Application number: 2021/92462	
What is the application for?:	Outline application for erection of detached dwelling
Address of the site or building:	rear of, 1091, Manchester Road, Linthwaite, Huddersfield, HD7 5LS
Postcode:	HD1 4QT

Type of comment: An objection	
Do you wish your comments to be published on the website anonymously?	Yes
Objection to planning application 2021/92462 Land to rear of 1091 Manchester Road, Linthwaite, Huddersfield HD7 5LS The heritage statement attached as part of the planning application is incorrect and highly subjective as it only indicates one photographed aspect of properties adjoining the plot in question and fails to acknowledge the extent of the grade 2 listed zone in which this development would sit. Firstly the proposed development is a 2 bedroomed build and not a 3 bedroomed one as stated in this assessment. Referring only to the properties in the photograph, It argues “ Whilst the buildings are of a grade 2 listed status, it is not immediately clear from an initial look” and then “The rest of the buildings structure though is authentic and uses hammer dressed stone with stone brackets to guttering and stone slate roof.” This is a biased argu

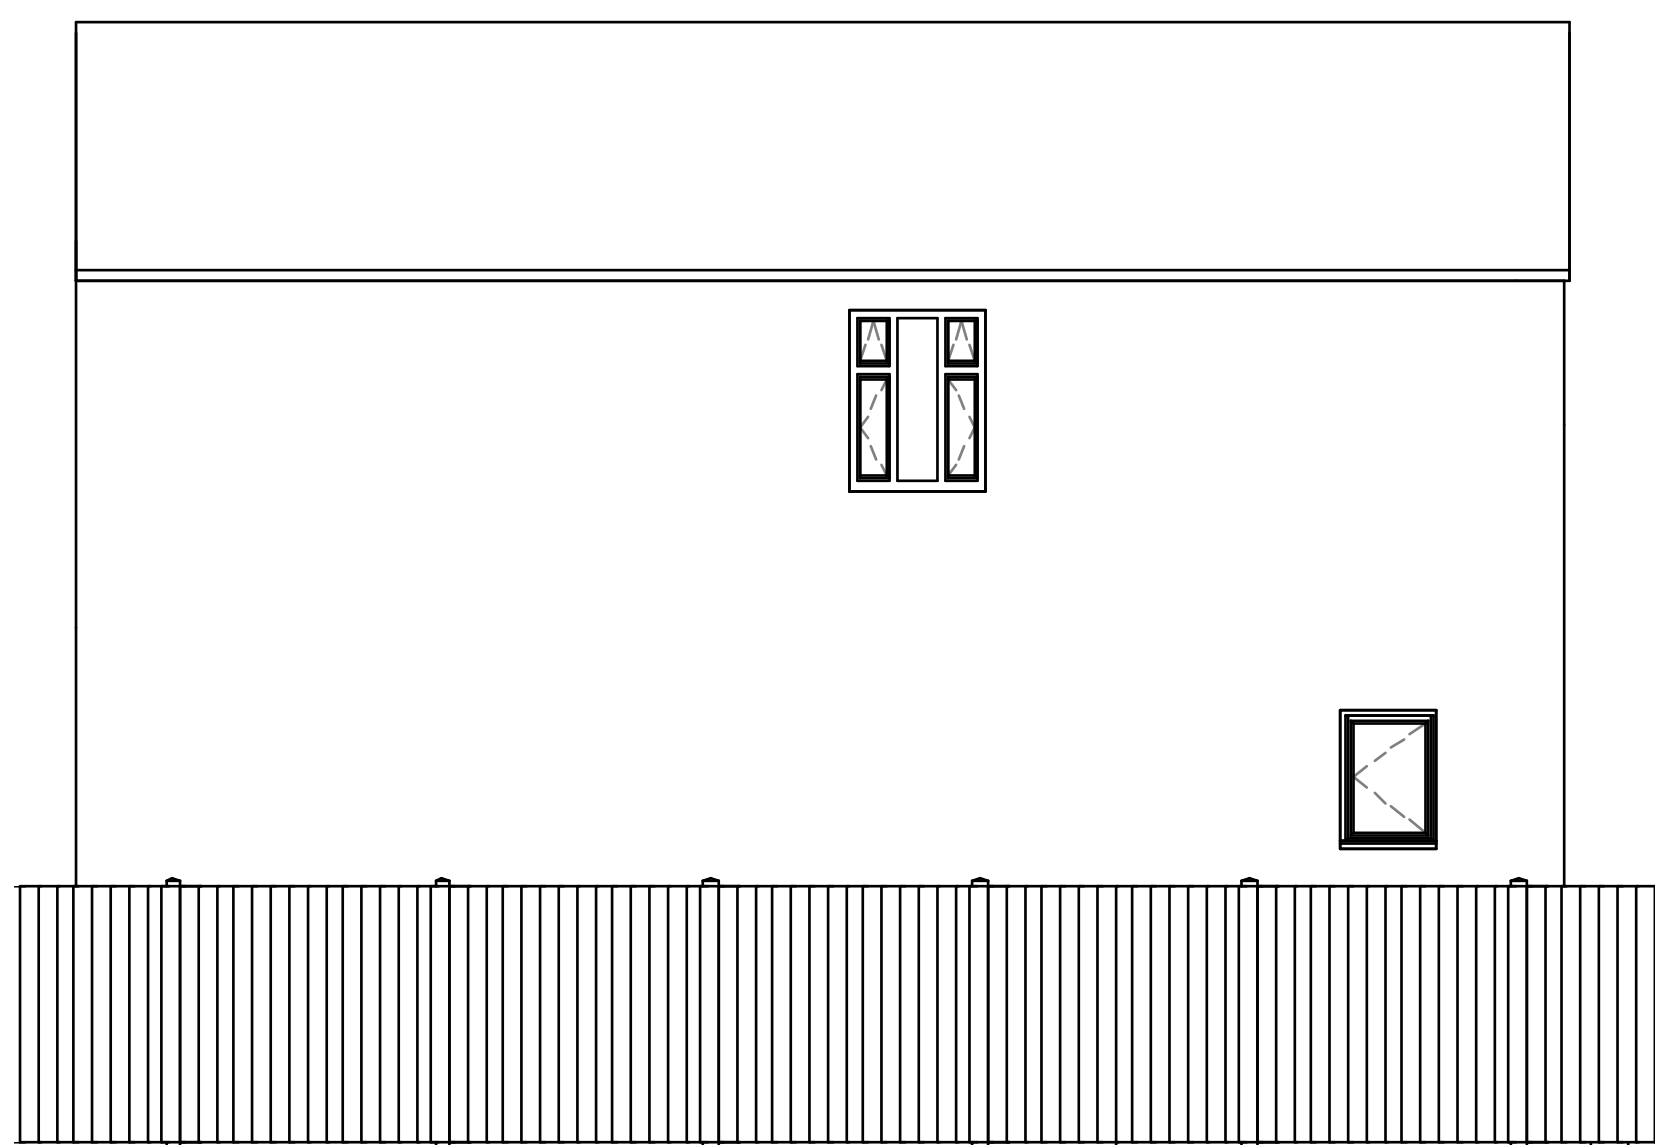
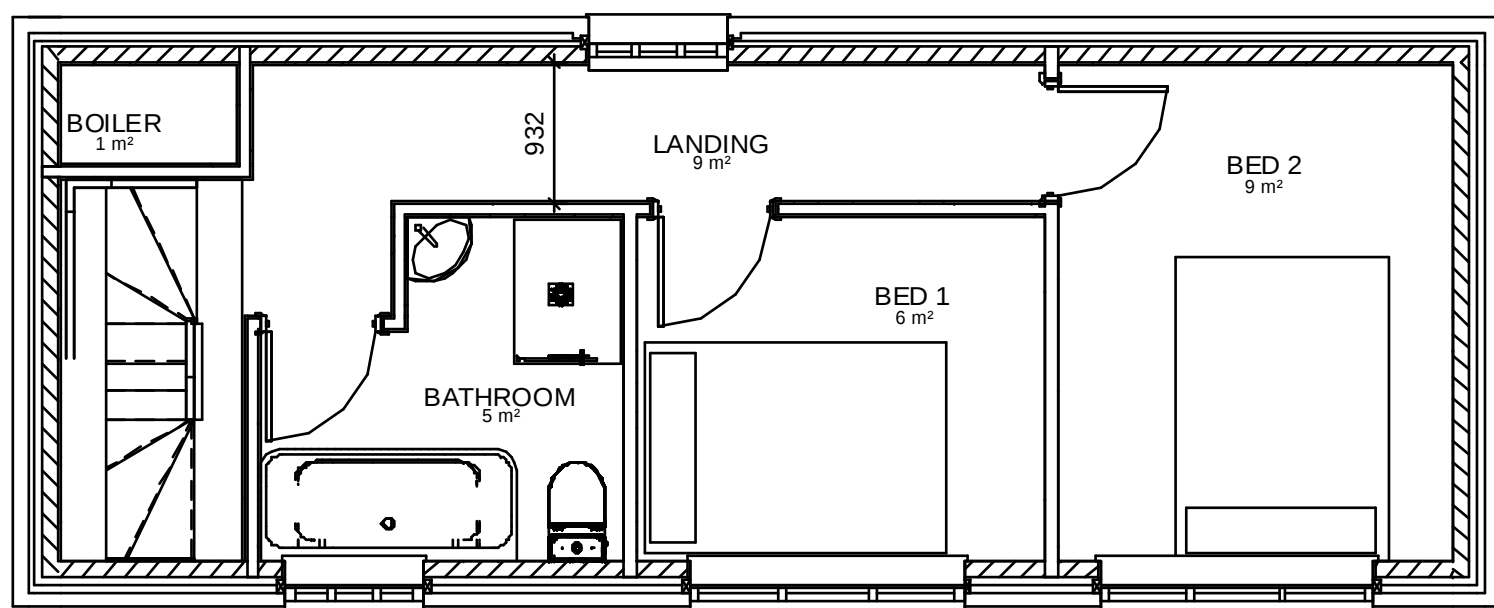
Albeit that it is suggested to use stone and slate in the new build, the actual placements of the windows in the proposed build do not reflect the weavers cottage style of its surroundings.

Furthermore on a practical level, the proposed one way driveway to the property would be a hazard for entering / exiting due to sight-lines and the amount of traffic using Linfit Fold to access the numerous properties on Bank Road and other housing estates.

three of the properties
on Manchester Road to which the plot adjoins. All of these properties will be greatly
affected by a lack of light and I am confident they would
object to the development on that basis.
